From: [Chadwick, James \(E,I&S\)](#)
To: [Oaklands Farm Solar](#)
Cc: [Evans, Mark \(E,I&S\)](#)
Subject: Deadline 7 response
Date: 06 December 2024 15:26:33
Attachments: [image001.png](#)

At the ExA's Third written questions it was requested that 'Please could SCC summarise any outstanding traffic and transport concerns at Deadlines 7 and 8 with suggestions about how they might be addressed?' Our position is set out below.

Figure 10.3: Scenario 2A Likely Construction Vehicle Routing

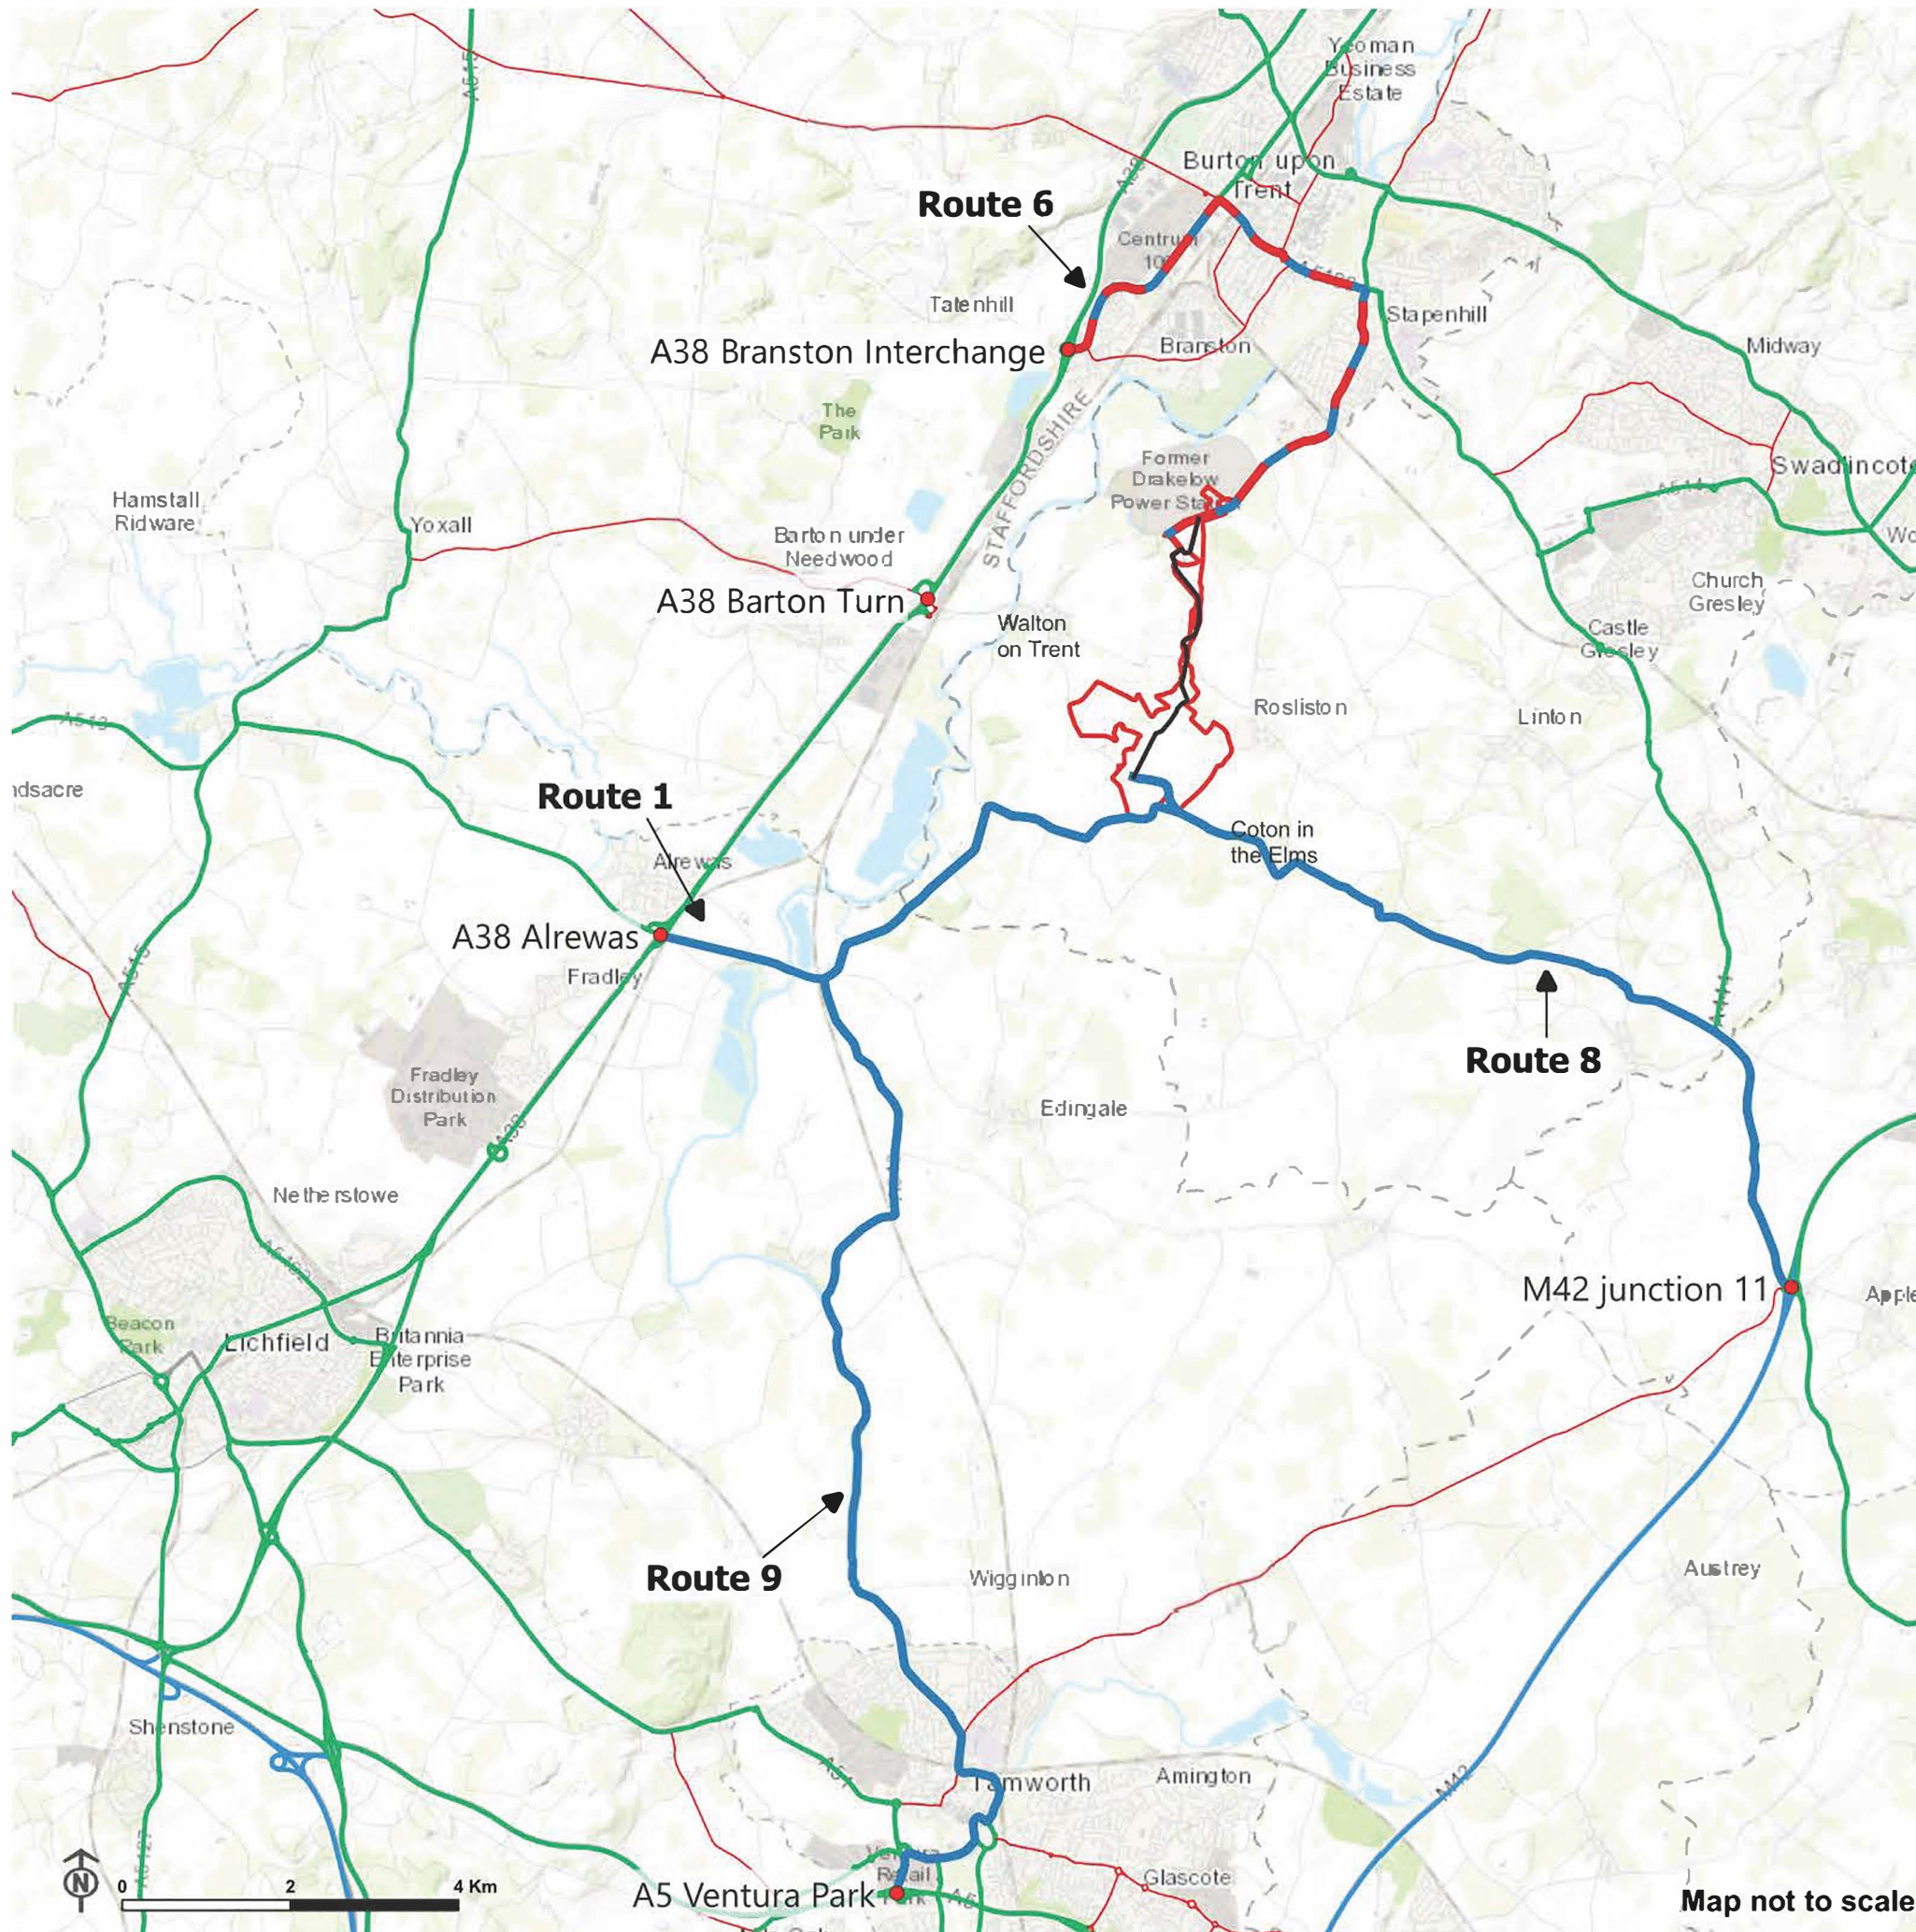
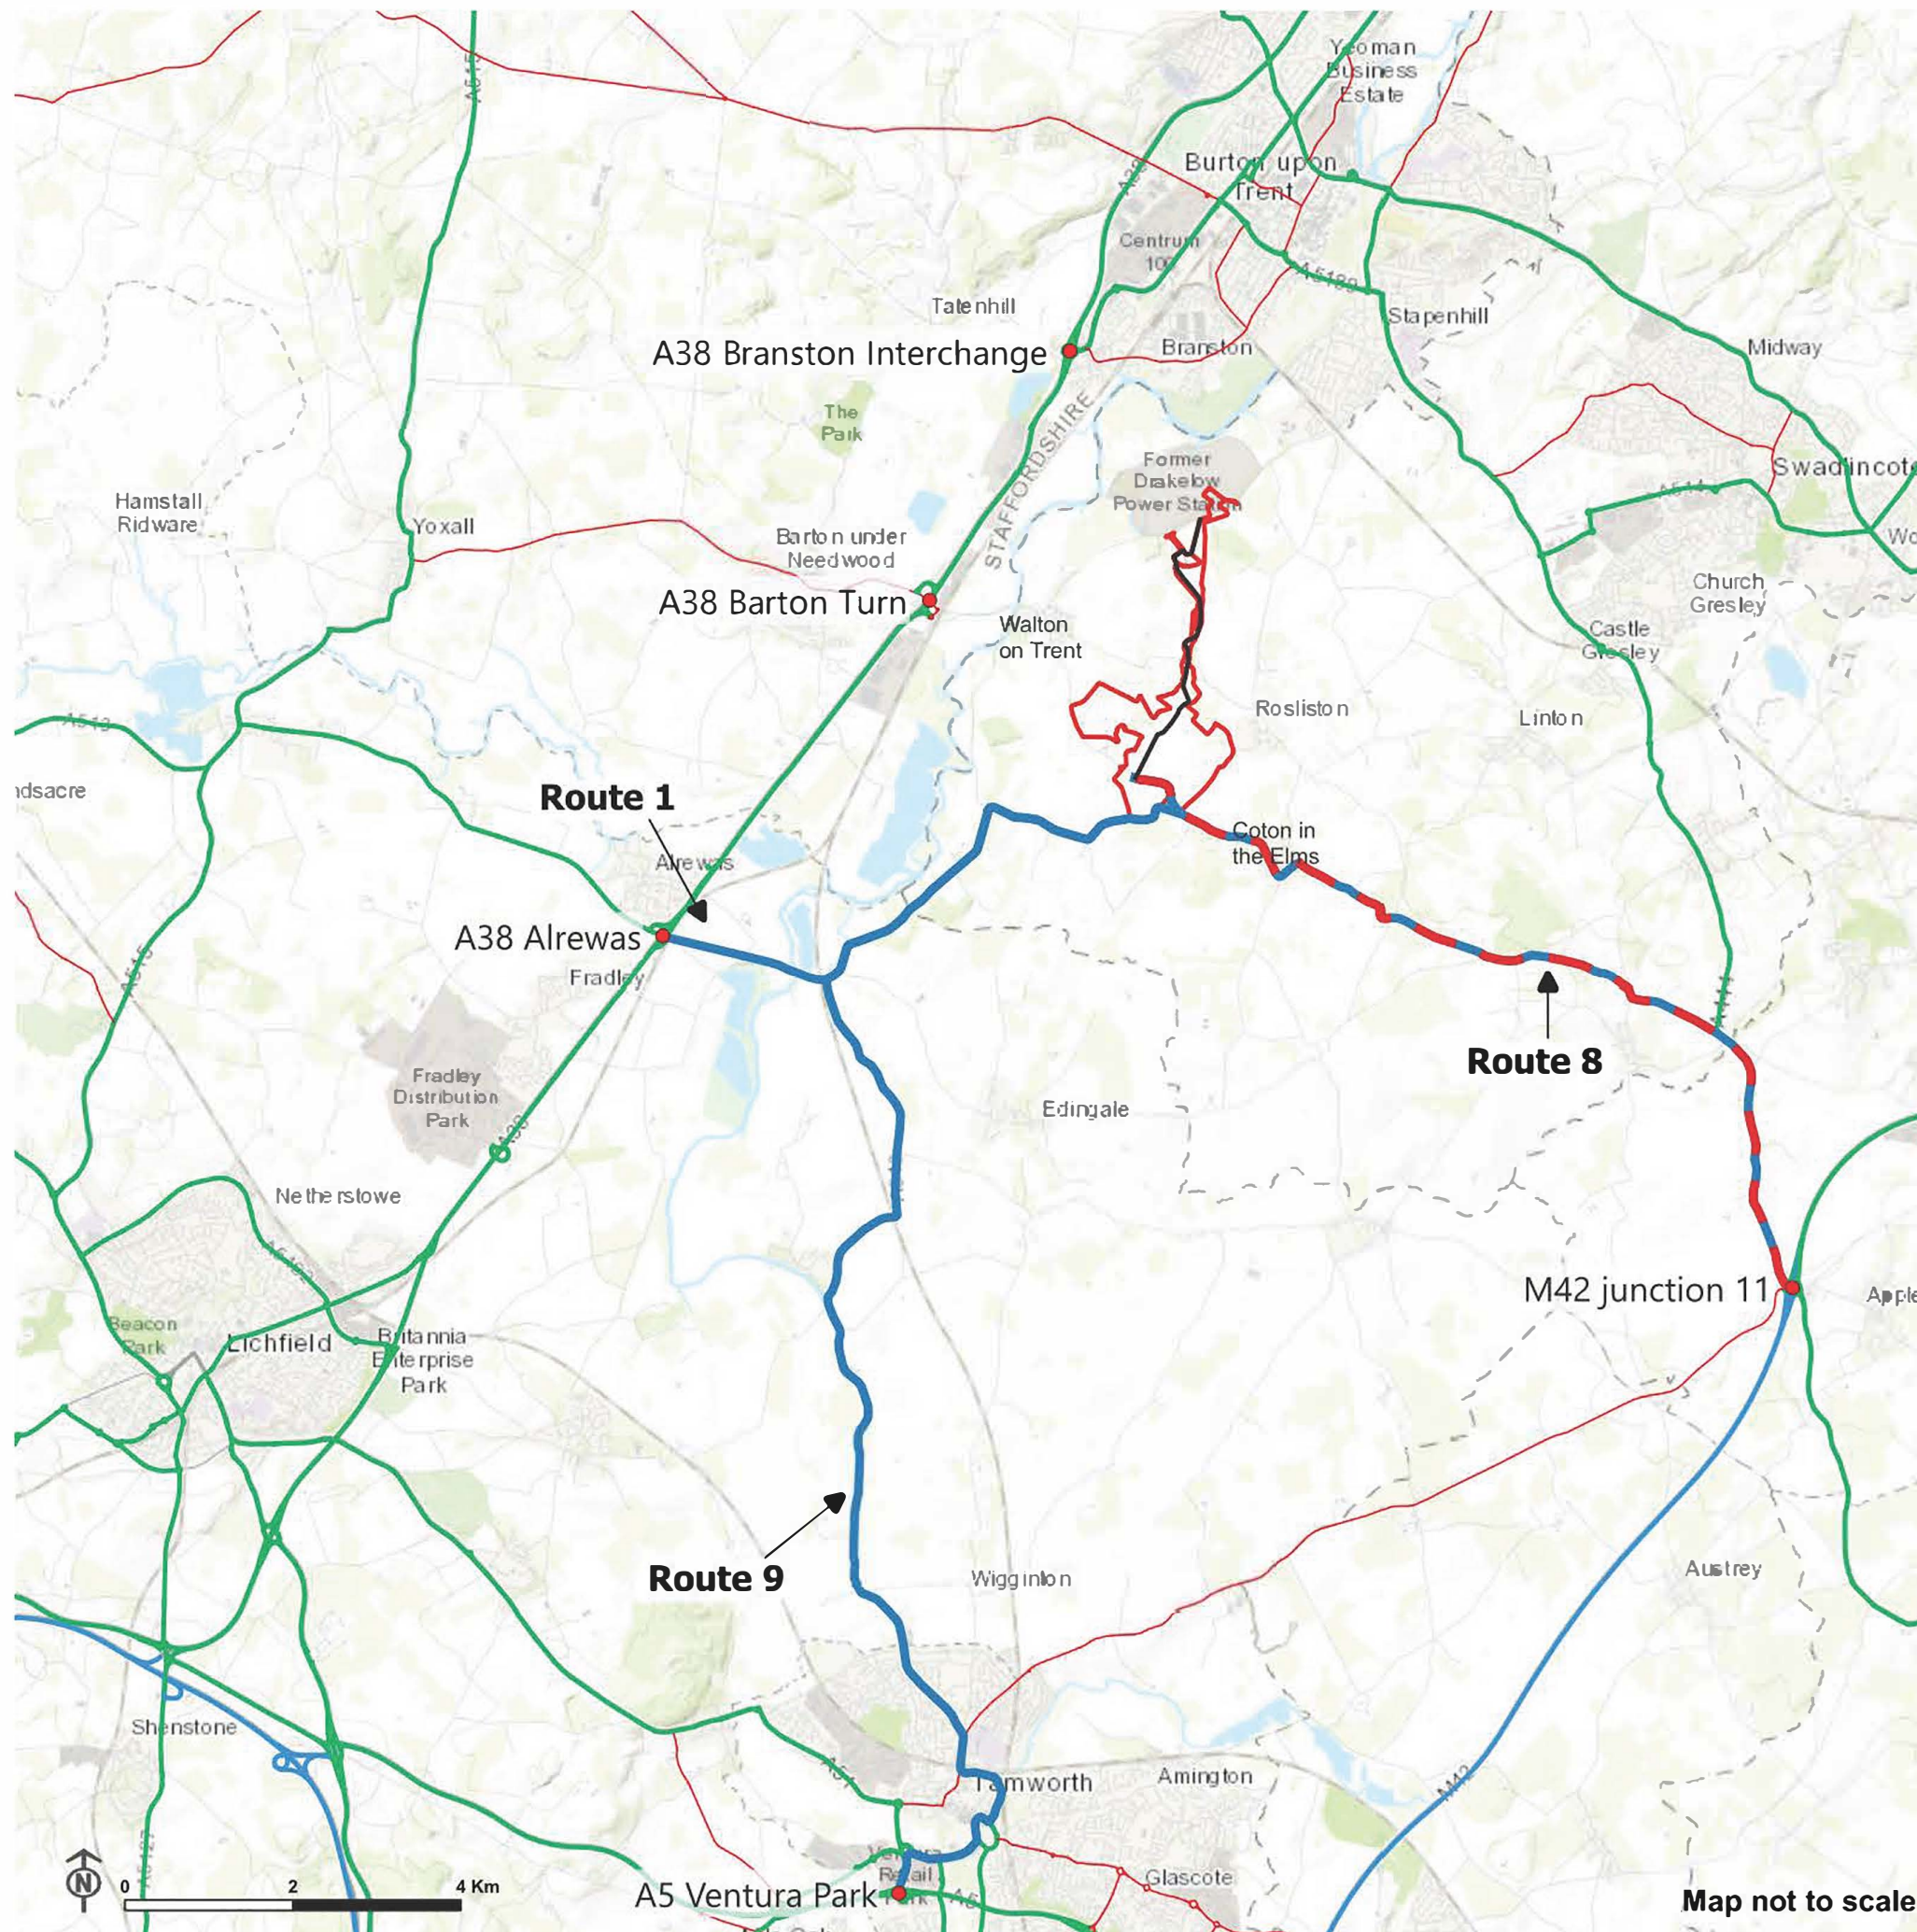
We maintain that should the Walton Bypass not be available for use for construction traffic, then we would like to see routes 2A and 2B used in conjunction with one another to lessen the impact of construction traffic on the residents of Stapenhill. We have discussed the matter with the applicant and have not been able to find a resolution. Should the applicant address our concern and allow some traffic to use route 2B then it will likely encounter new objections from the Derbyshire authorities over impacts on their residents. We accept the ES findings for the impacts of construction traffic within Staffordshire for route 2A however, we do not believe a consideration has been fully given to the impacts of combining routes 2A and 2B. That said it would still be likely objections would arise from elsewhere if a different conclusion was drawn. Therefore, we do not believe this matter can be resolved by agreement between the applicant and is a matter for the ExA to make a judgement on.
